# CITY OF ALBUQUERQUE

May 9, 2019

**Re: Blake's Lotaburger LLC**  
**1801 Juan Tabo Blvd NE Albuquerque NM 87112**  
**Traffic Circulation Layout**  
Engineer's/Architect's Stamp **04-22-19** (H21D012)

SITE PLAN
JUAN TABO & SNOW HEIGHTS

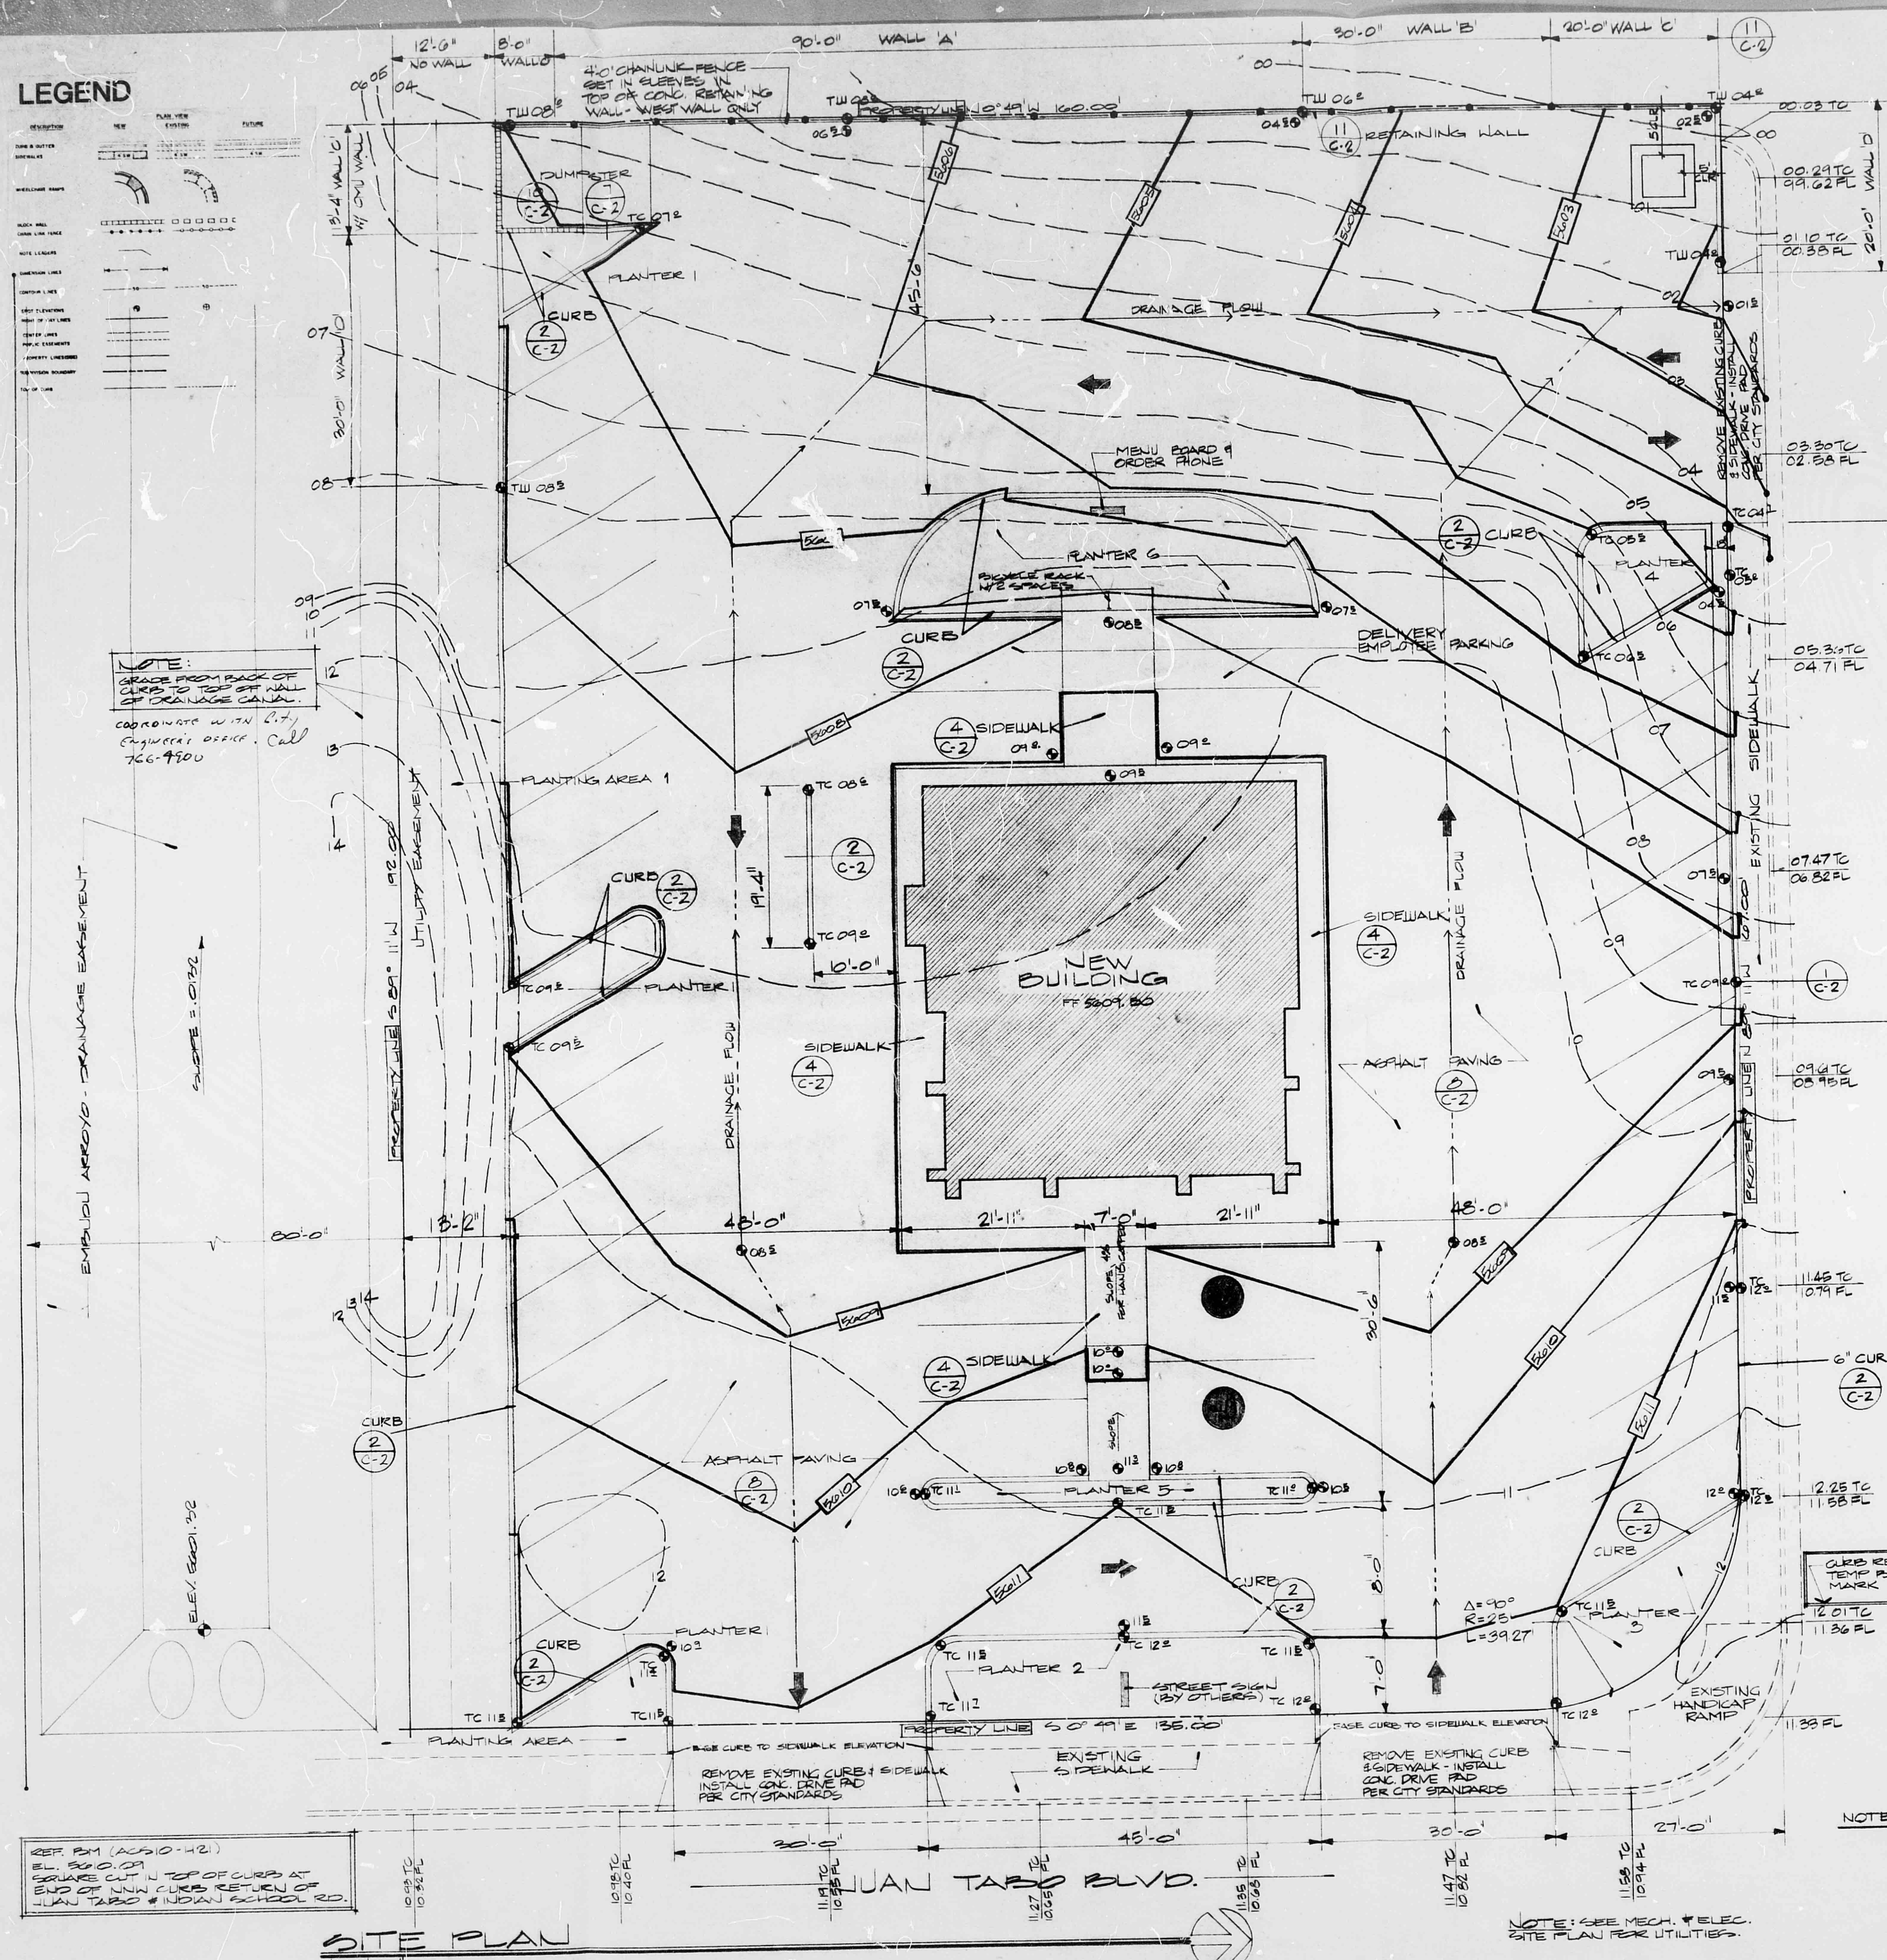
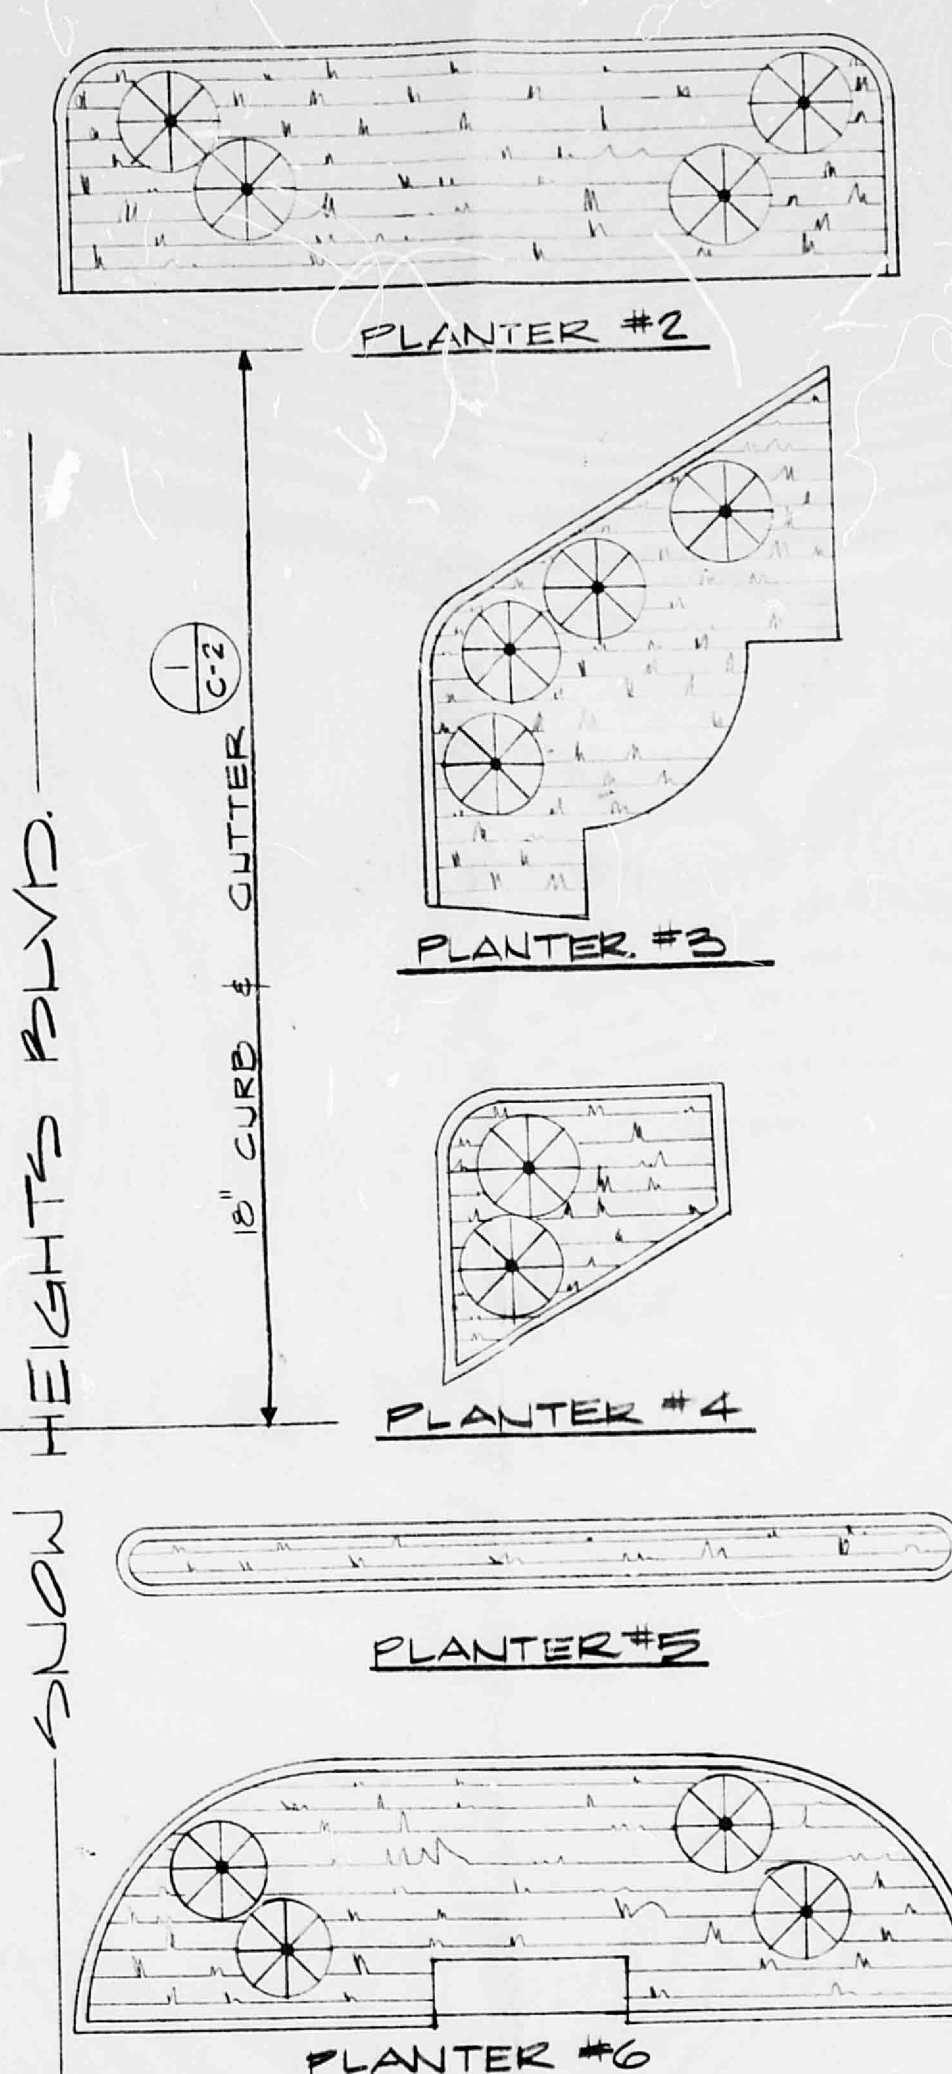
1. Stripe the walkway to identify it as a pedestrian walkway.
2. The type of ramp drawn for the access in Juan Tabo is a wrong type. Consider using parallel or perpendicular ramp type with truncated dome.
3. Remove all the bubbles
4. The \$75 resubmittal fee was not paid.
